Active
Travel
England

Your Ref: 2021/1090
Our Ref: ATE/23/00773/HYB
Date: 15 November 2023

Active Travel England Planning Response Detailed Response to an Application for Planning Permission

Site Address: Land south of Barugh Green Road and east of Higham
Common Road, Barnsley

Link road drawing

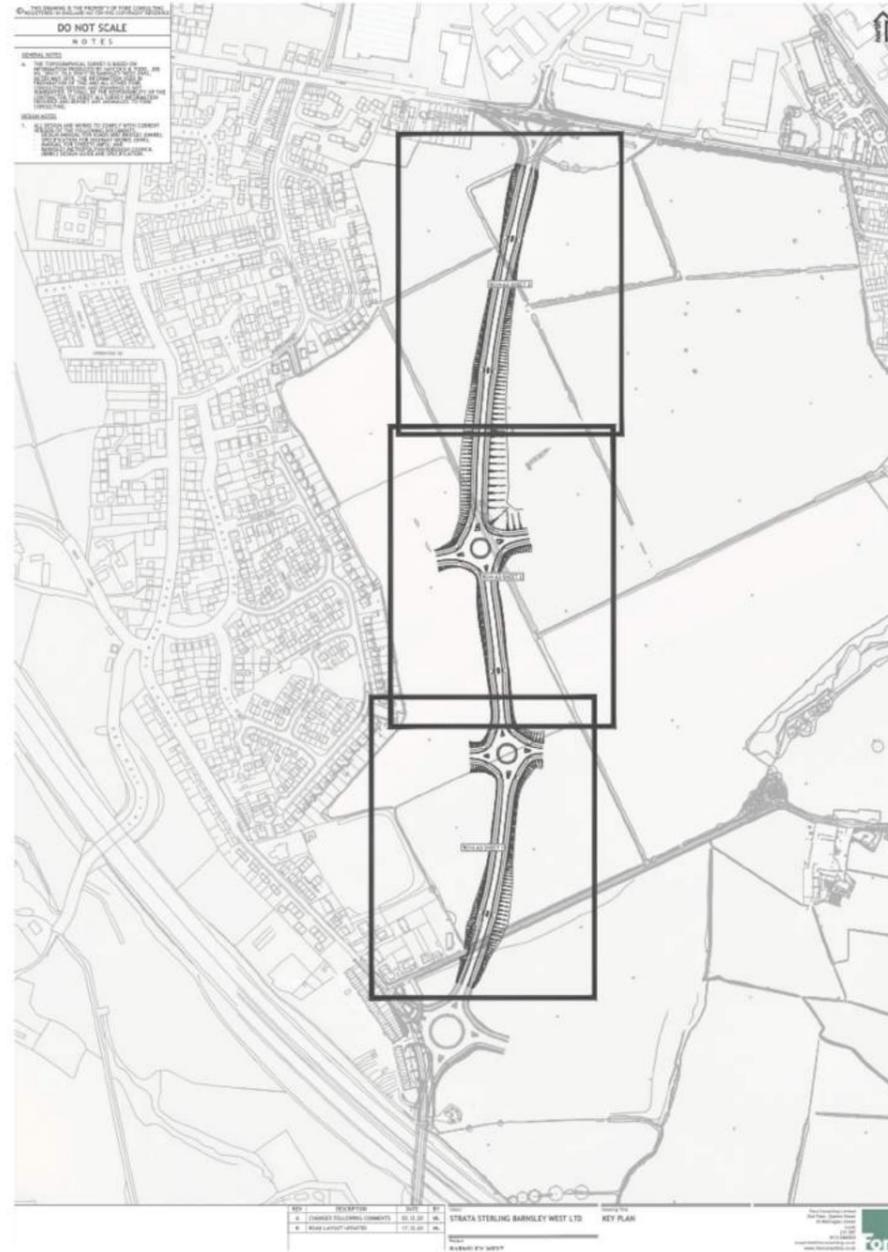
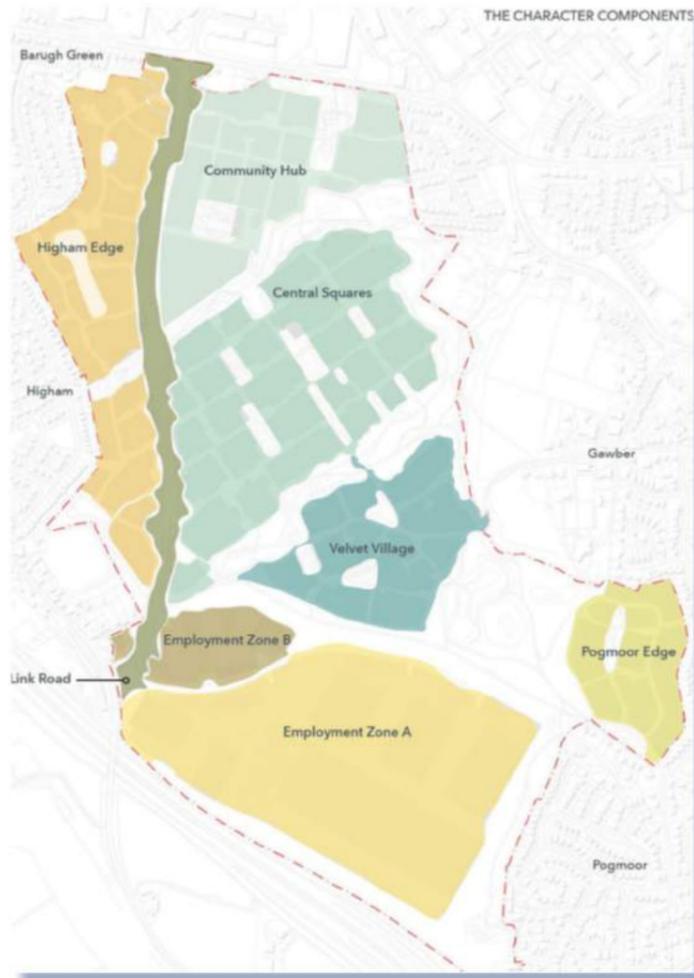
- The proposed Claycliffe link road includes 3m-wide shared footways-cycleways on either side of the carriageway. Shared use routes (i.e. a path or surface which is available for use by both pedestrians and cyclists) should be avoided along all new streets, unless they fit within the limited acceptable situations listed in LTN 1/20 (see paragraph 6.5.6 and section 1.6 (2)) and ATE does not consider this development to meet these criteria. Section 1.6 (2) of LTN 1/20 states that “on urban streets, cyclists must be physically separated from pedestrians and should not share space with pedestrians.” This is further supported by paragraph 6.5.4 which states, “the conversion of a footway to shared use should be regarded as a last resort. Shared use facilities are generally not favoured by either pedestrians or cyclists.”

- To be in accordance with national design guidance, the development should therefore provide dedicated space for cyclists on or alongside the Claycliffe link road. ATE would advise that the most appropriate infrastructure in this case would be cycle tracks adjacent to footways. ATE would advise that footways be 2m wide and cycle tracks run alongside these, separated from the carriageway by the grass verge as already proposed. The segregation between the cycle track and footway can be achieved through level changes (see Figure 6.3 of LTN 1/20) and ATE would advise that materials also differ to provide clear, visually segregated spaces.

- ATE recommends that segregated cycle tracks be employed along the full length of the Claycliffe link road, and also on the primary road that runs between the two roundabouts past the entrance to the school and civic centre.

- ATE also raises concern with the use of narrow uncontrolled crossings on the Claycliffe link road as the only means of crossing the highway outside of the roundabouts. It is again advised that the applicant reviews guidance contained within LTN 1/20 on successful crossings – see table 10-2, and section 10.4.

- Given the speed and volume of traffic, ATE would prefer to see at least one of the link road crossings adjacent to Phase 1 be designed to be a crossing (with parallel cycle crossing) that gives greater priority to pedestrians and cyclists through either a zebra or toucan crossing.

- Removal of the shared use paths adjacent to the Claycliffe link road, to be replaced by segregated footways and cycle tracks. A similar arrangements should be shown indicatively on the road between the roundabout that passes the school and civic centre.

- Improvements to the proposed uncontrolled refuge crossings to provide greater priority to pedestrians and cyclists, with segregated crossing space to comply with LTN 1/20.
